Sterling Ranch Comment Response Letter

RE: Sterling Ranch Comments -PPR-19-030 Sterling Ranch Wastewater - CSU Line

Enclosed are the response to comments provided by El Paso County Development Services Department on the Sterling Ranch Project; PPR-19-030 Sterling Ranch Wastewater - CSU Line, Second Submittal

## COUNTY OF EL PASO, STATE OF COLORADO SITE DEVELOPMENT PLAN

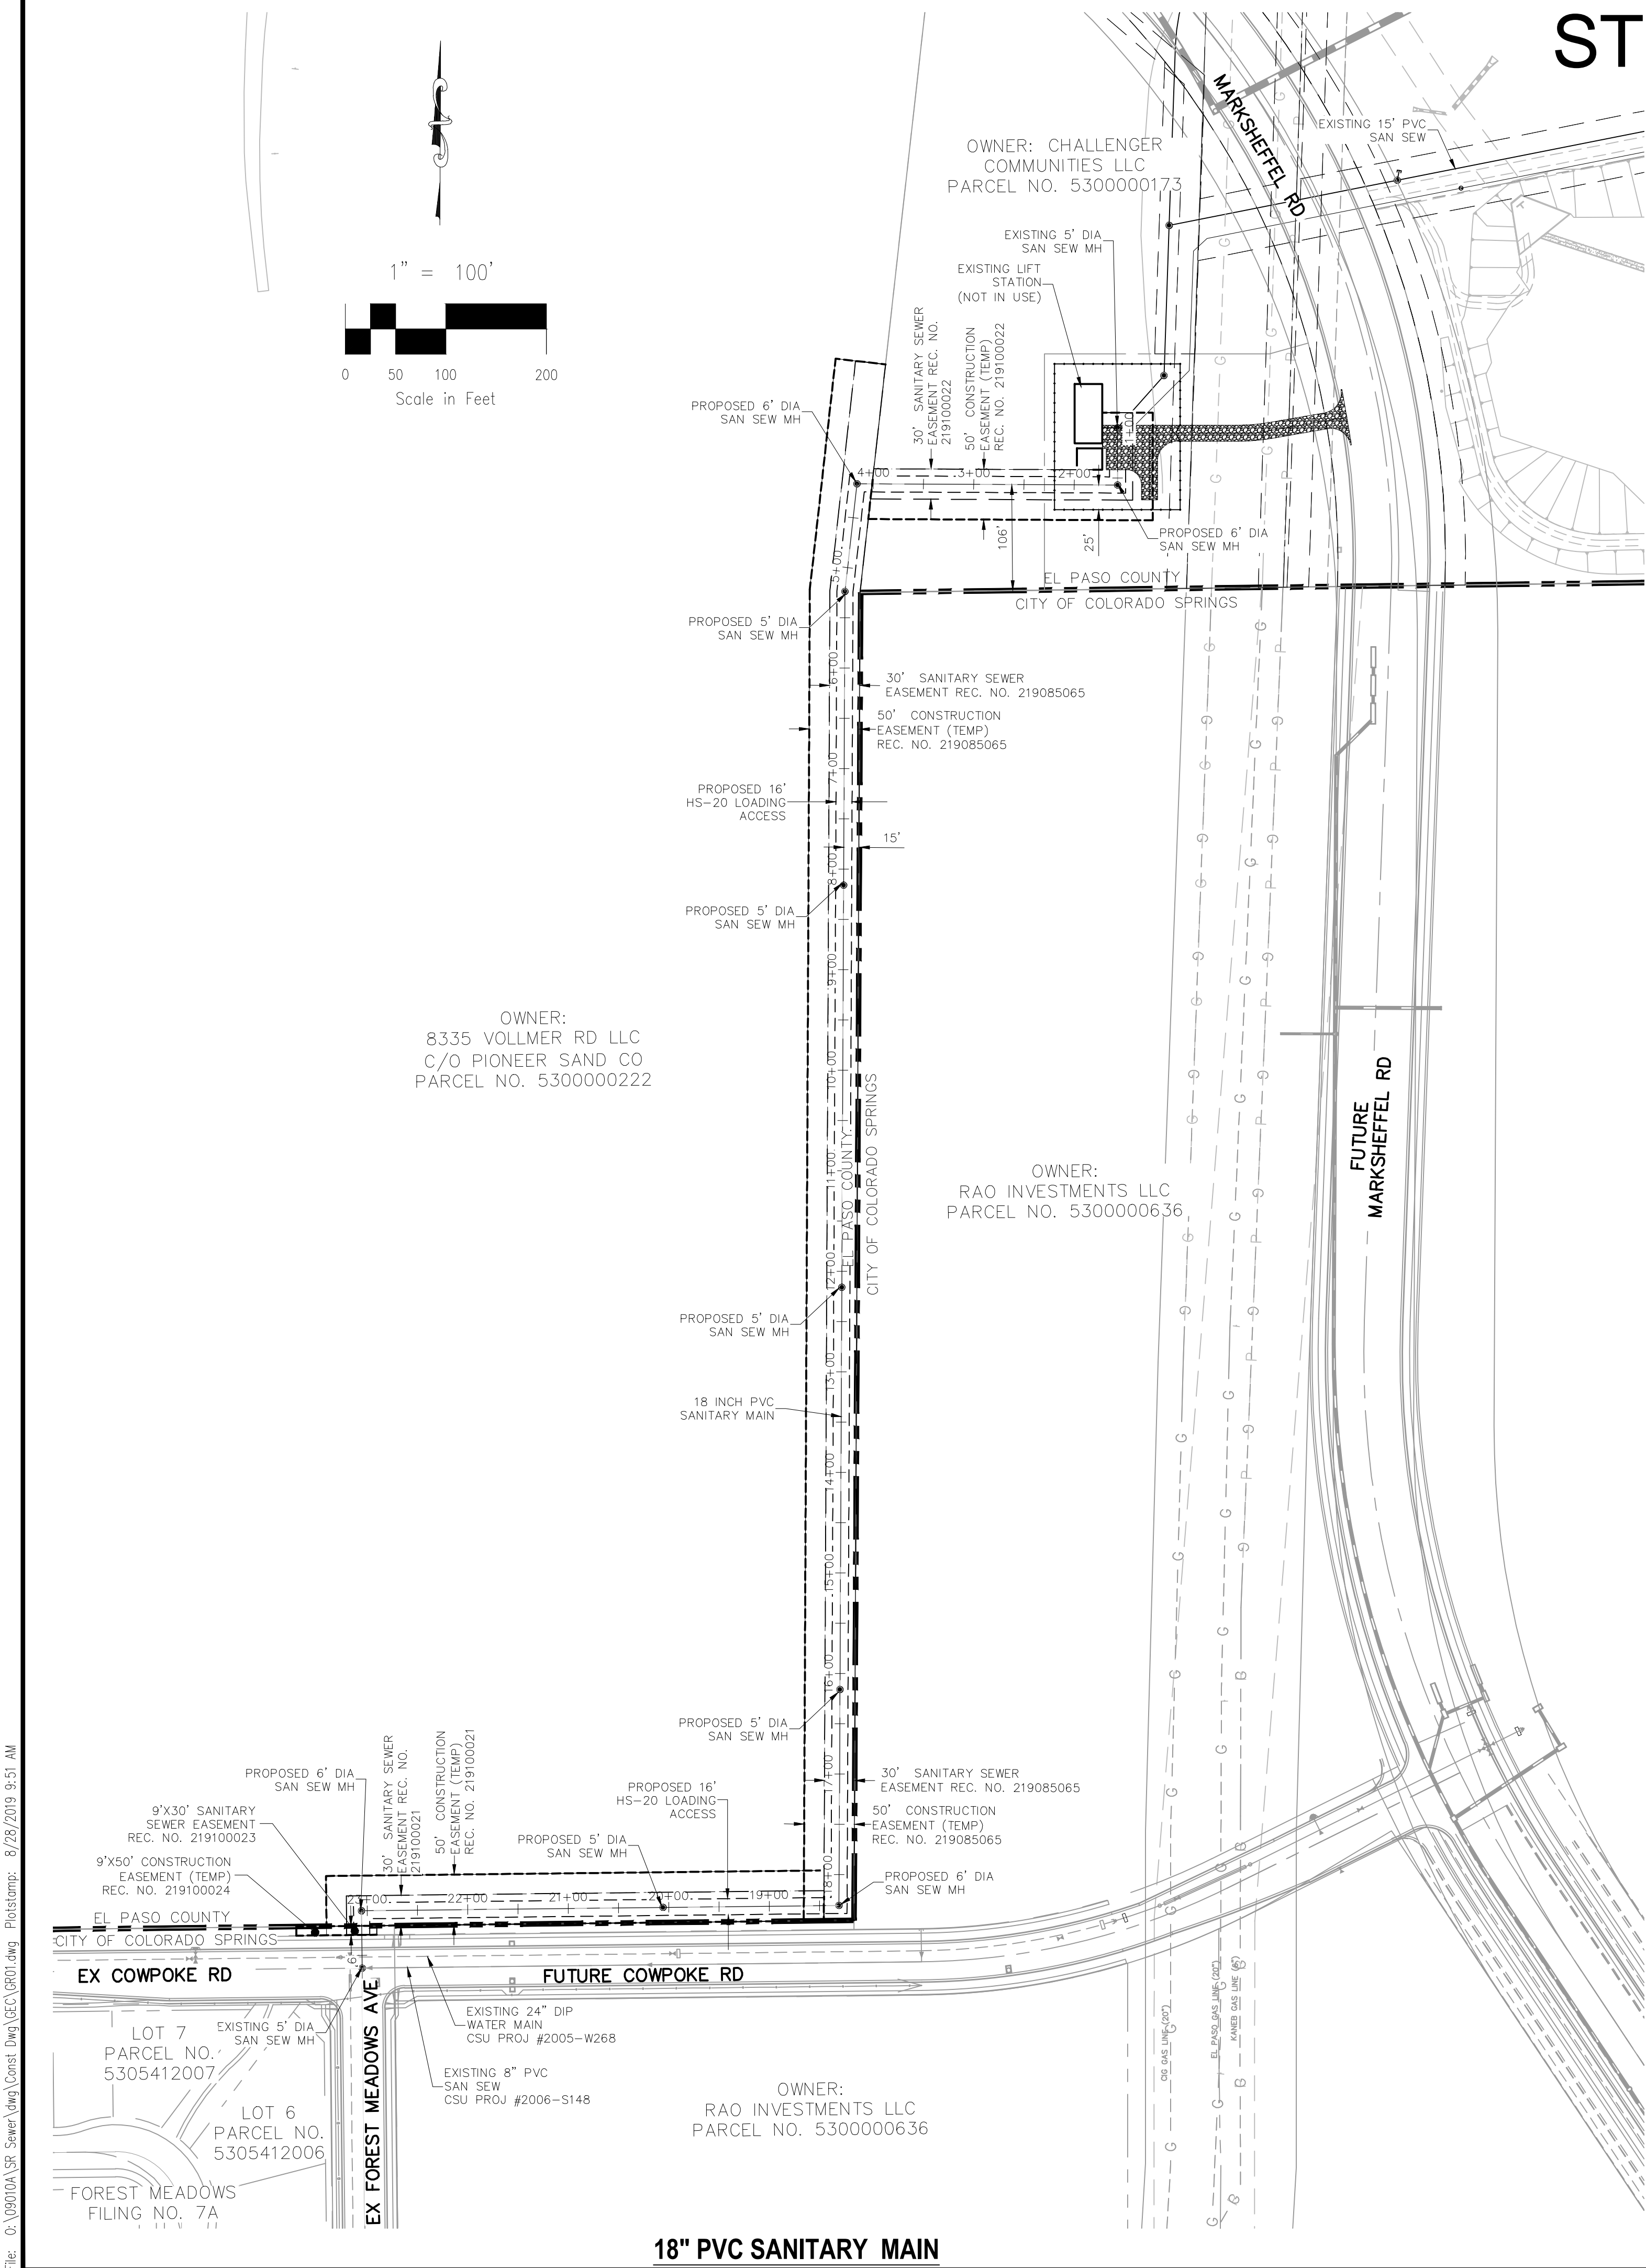
1. See Planning Site Development Plan redlines; Engineering has no additional comments on the Site Development Plan but will review revisions provided on the next submittal. **The Site Development Plan is not required since the 18" sanitary main is by-passing the lift station.**

# GRADING AND EROSION CONTROL PLANS

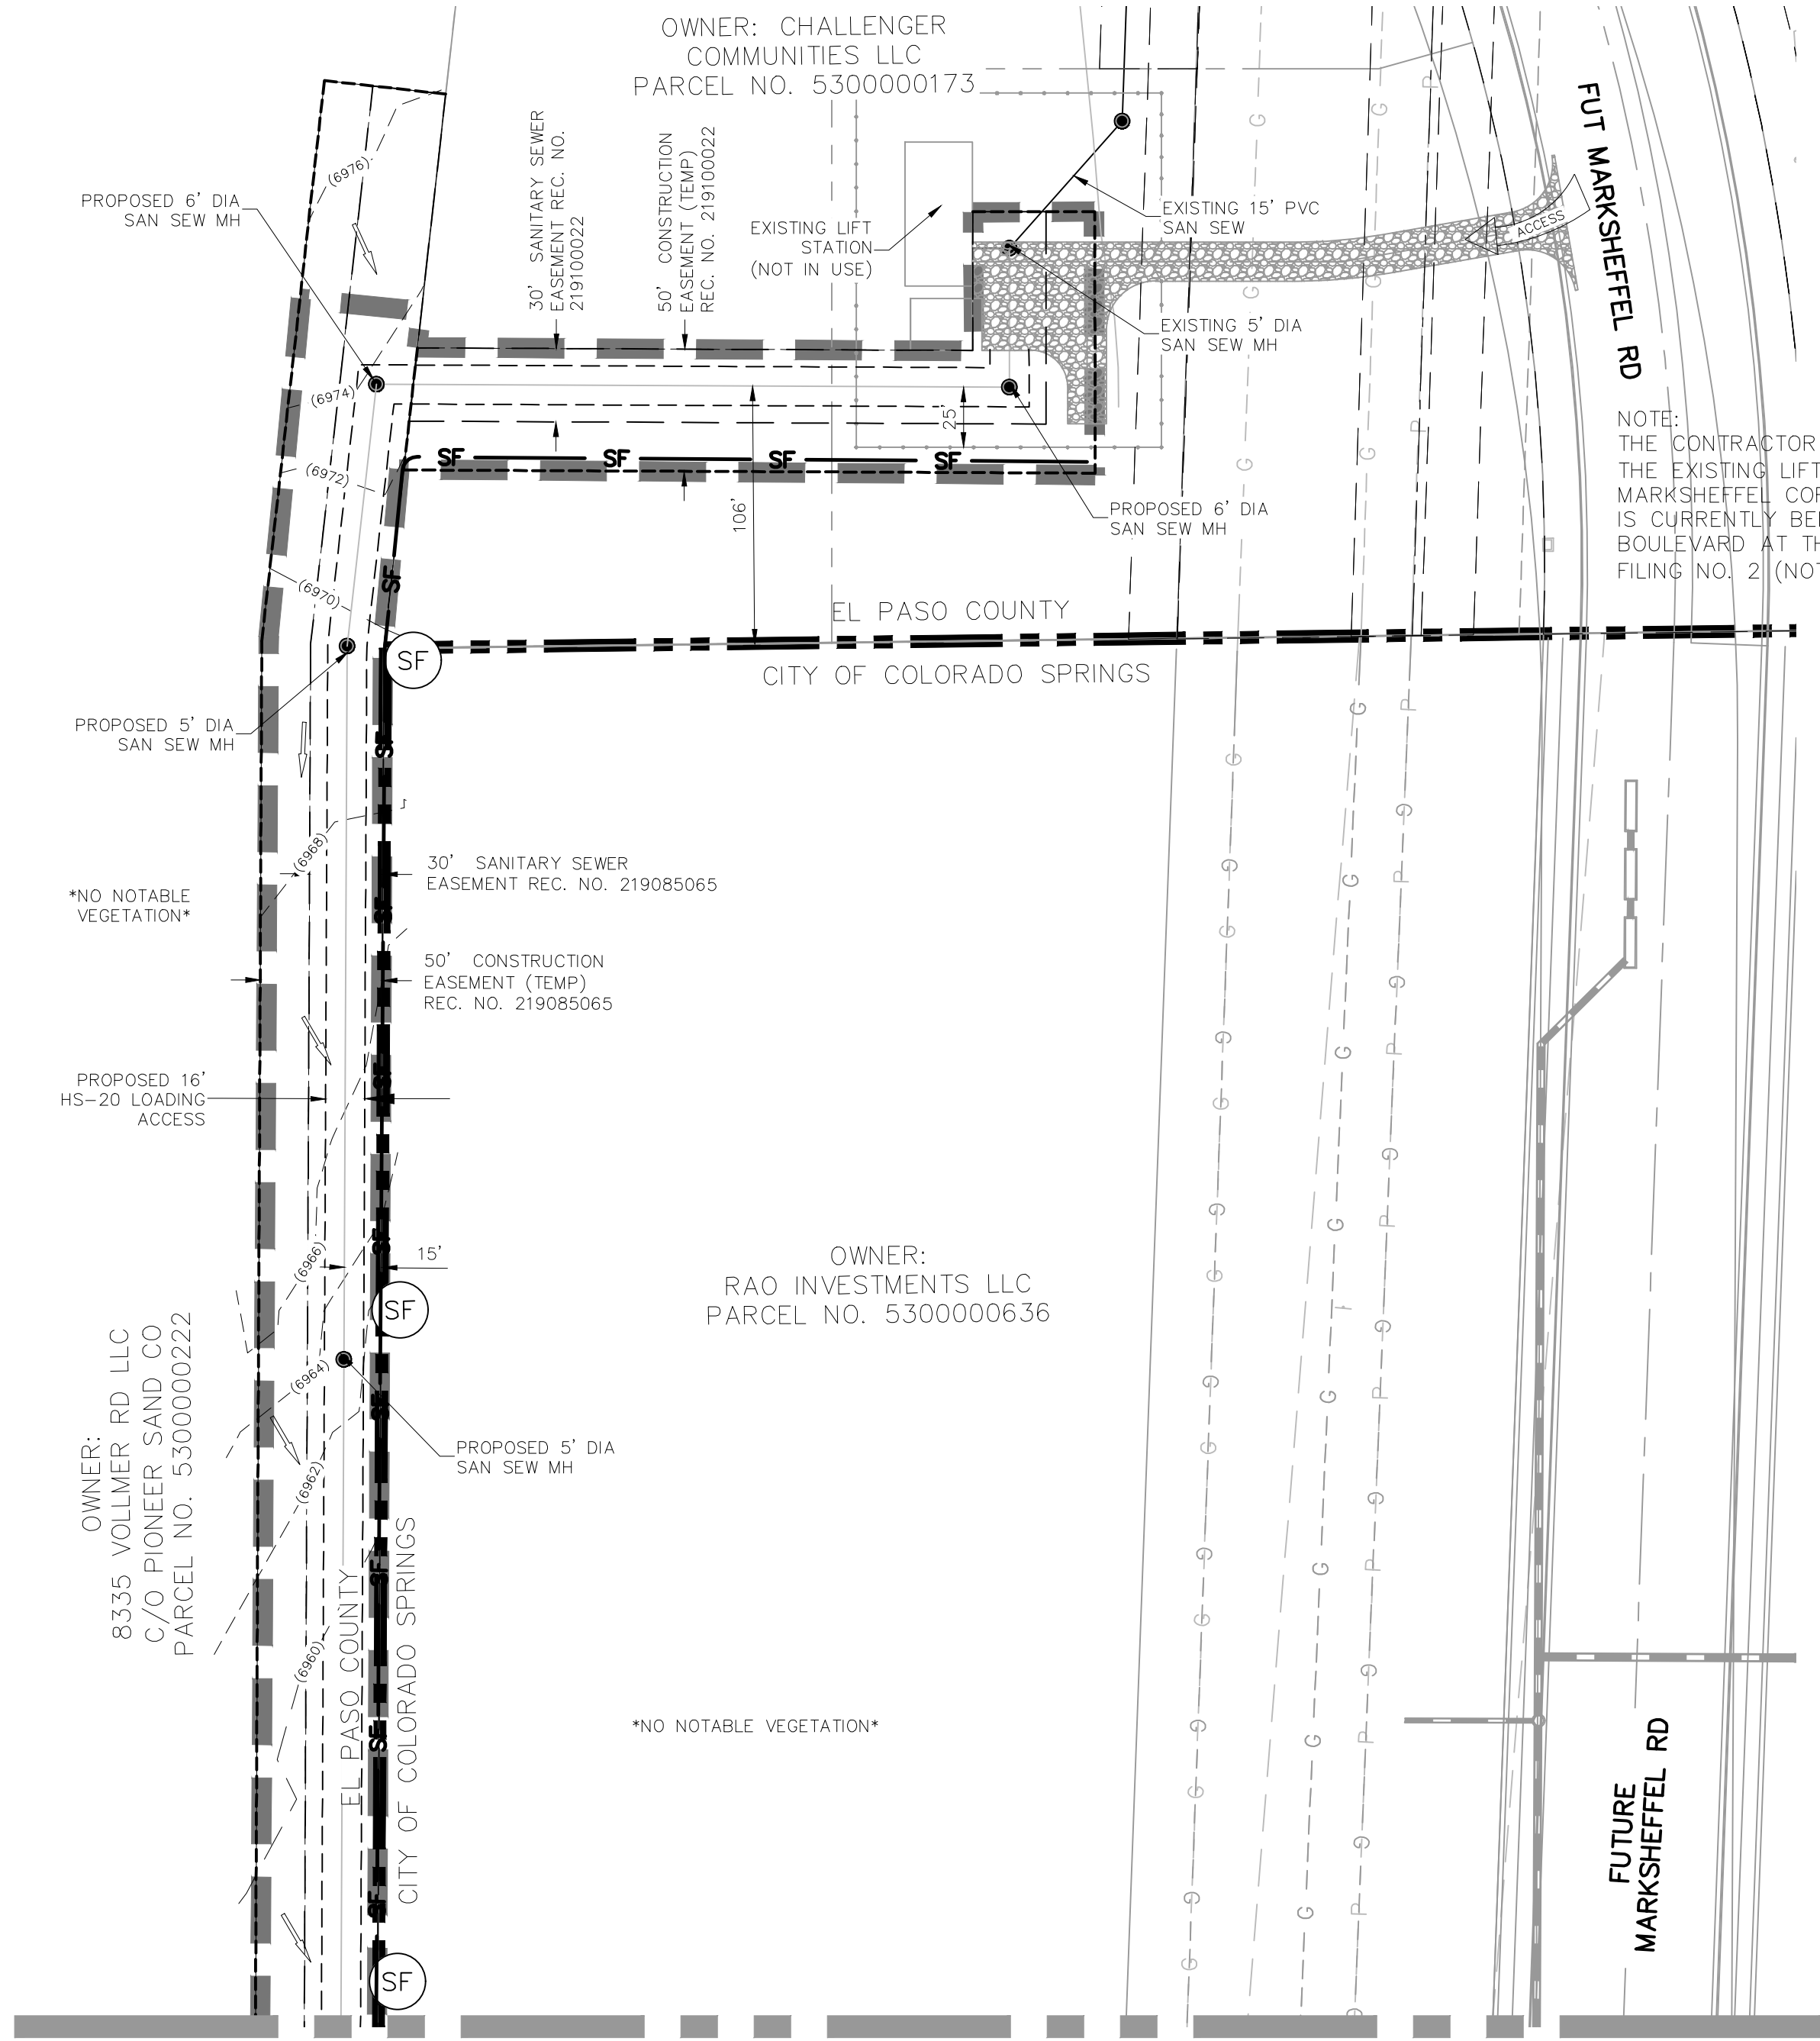
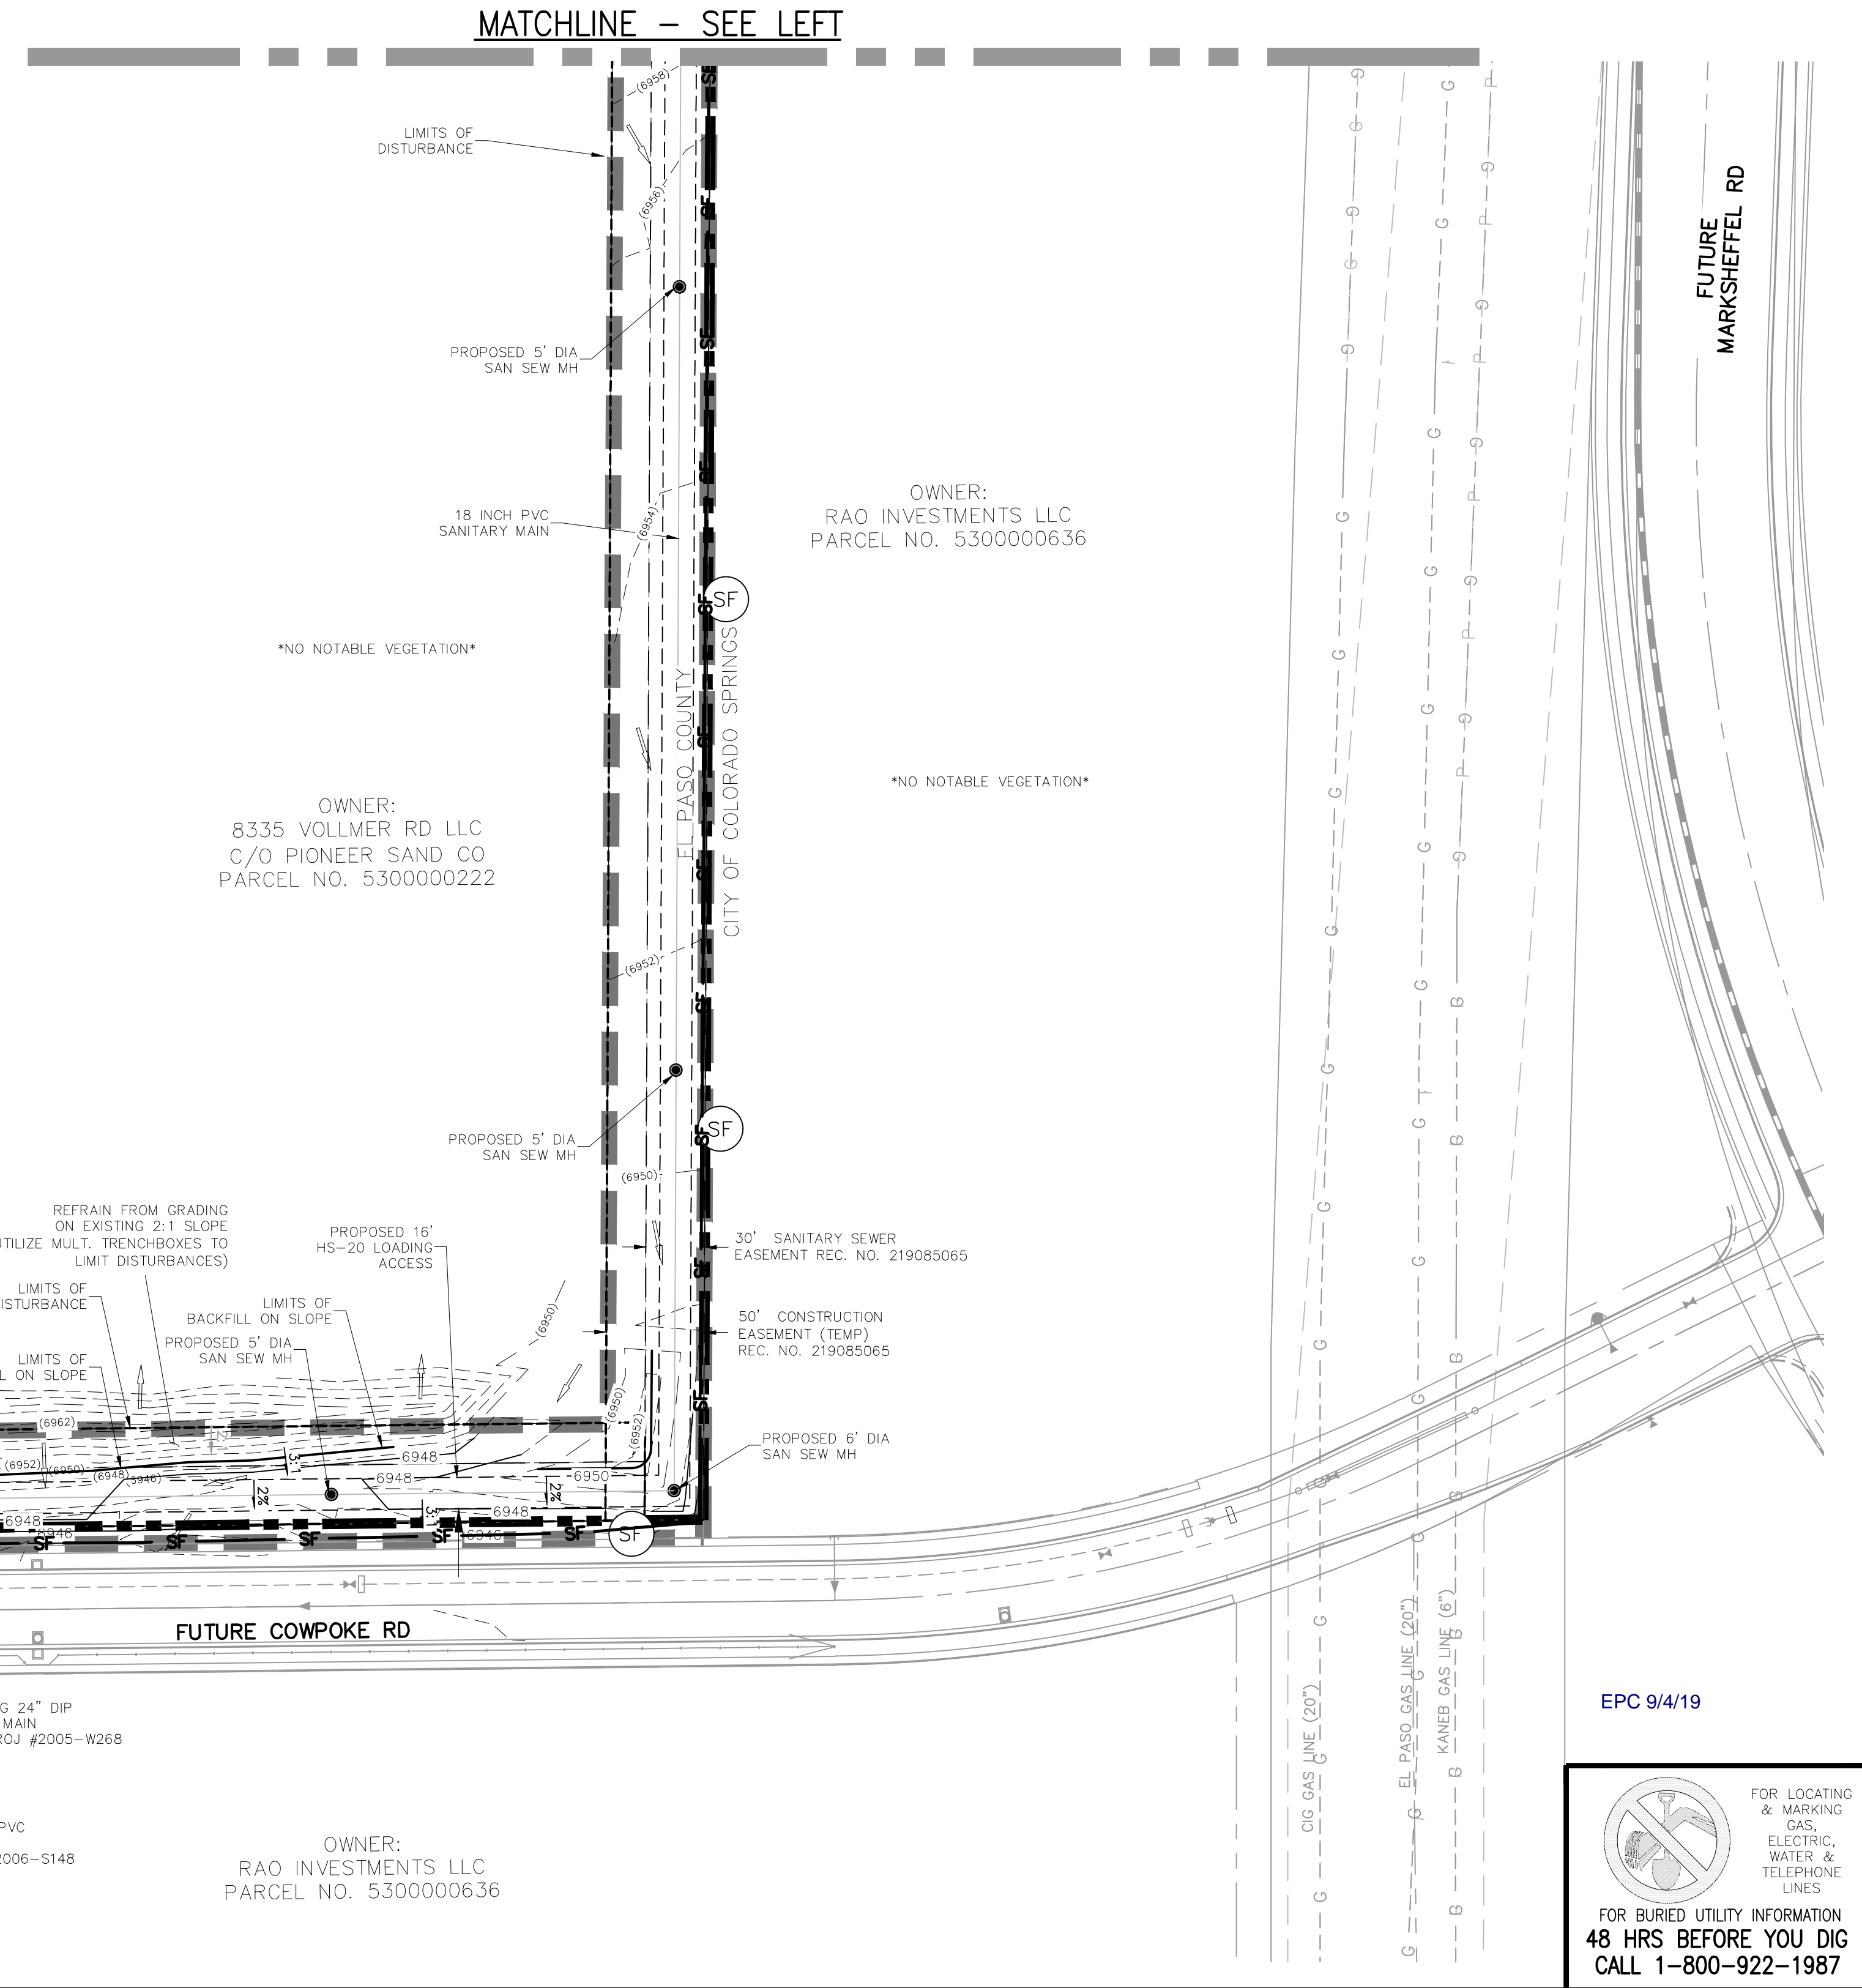
1. It appears that this project will disturb greater than one acre, and even if this sewer line construction does not in itself, it would be determined to be part of a larger common plan of development under the County's updated MS4 and ECM provisions. Provide a GEC Plan; this can be included in the CD set. **A GEC has been submitted.**
2. Ensure that all GEC Plan and SWMP checklist items are provided. GEC and SWMP checklists will be reviewed in detail with the next submittal. For any unknown/undetermined items, add a note to the GEC Plan stating how they will be addressed. **A SWMP has been submitted.**
3. Provide the updated ESQCP permit. **The ESQCP has been submitted.**
